PORTLAND MAINE

August 6, 2008

RE: 87 Walnut Street – 012 G019 – R-6 – two-story rear deck – permit #08-0566

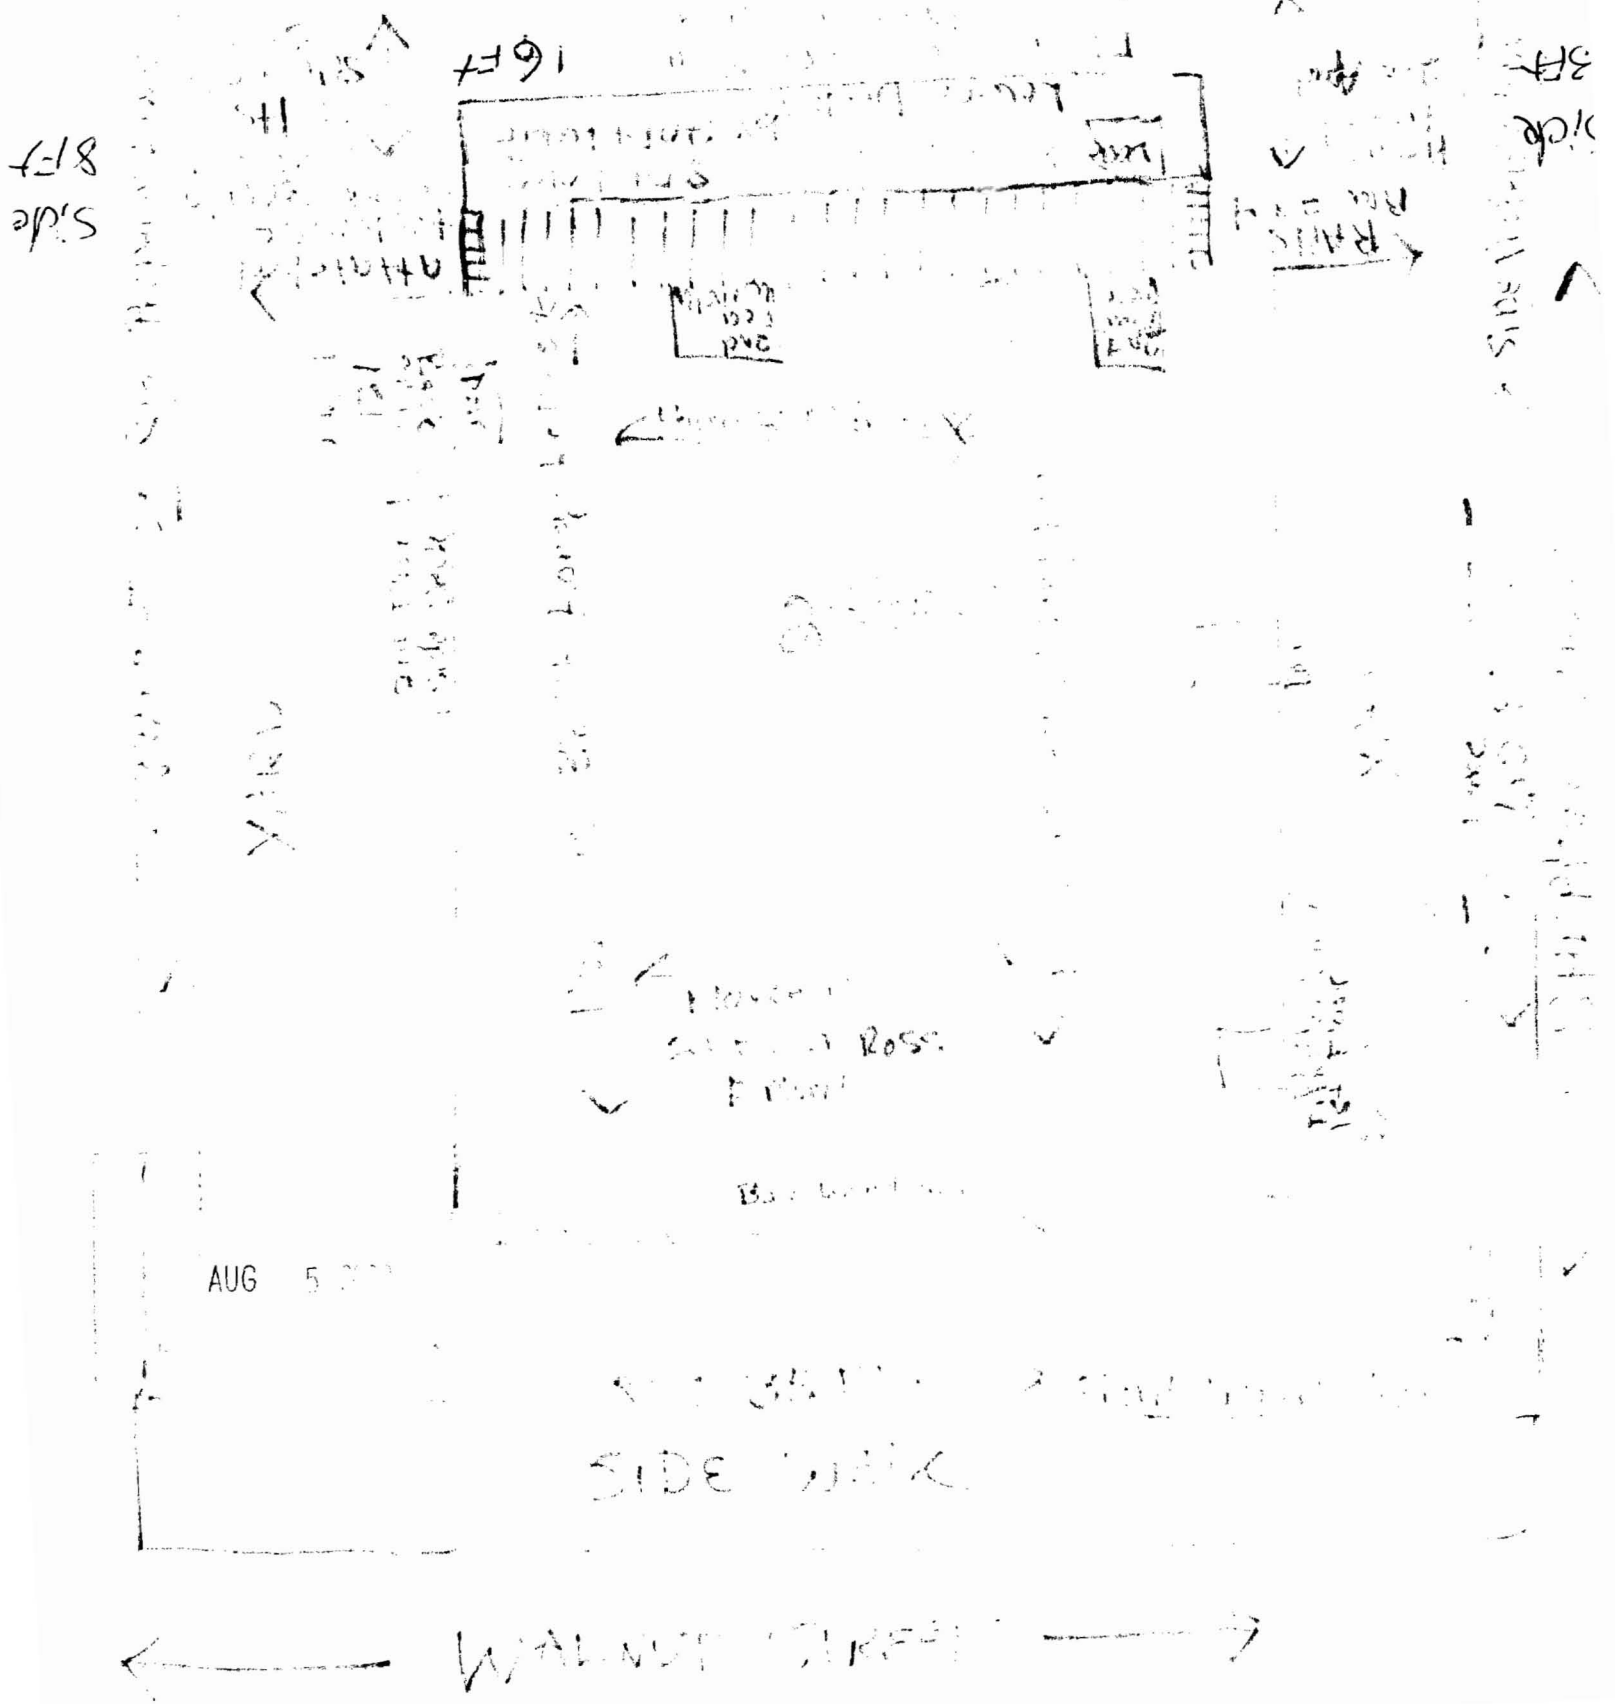
Section 14-139(d) of the ordinance states the required yard dimensions for the R-6 zone. The required rear yard setback is twenty feet. According to the plot plan, the existing structure is only sixteen feet from the rear property line and the proposed two-story deck is only eight feet from the rear property line, so it does not meet the required rear setback of twenty feet.

The required side setback for a two-story structure is ten feet for each side. The left side setback is given as eight feet, so it does not meet the required side yard setback. Also the numbers on the plot plan for the side yards do not appear to be accurate. The proposed two-story deck is twenty feet wide. The right side setback was given as thirteen feet, and the left side setback was given as eight feet. These numbers add up to a total width of forty-one feet, but the lot is only thirty feet wide at the rear. The numbers on the plot plan need to be accurate.

Section 14-139(e) states that the allowable maximum lot coverage is fifty percent of the lot. The lot is 1921 square feet, so the allowable maximum lot coverage is 960.5 square feet. The existing structure is 947 square feet. The proposed two-story deck is 160 square feet. The total square footage would be 1107 square feet, which is 146.5 square feet over the allowable maximum allowable lot coverage.

Since the proposed two-story deck does not meet the required rear or side setback and is over the maximum allowable lot coverage, the permit is denied and the decks must be removed. You have the right to appeal my decision. If you wish to exercise your right to appeal, you have thirty days from the date of this letter in which to appeal. If you should
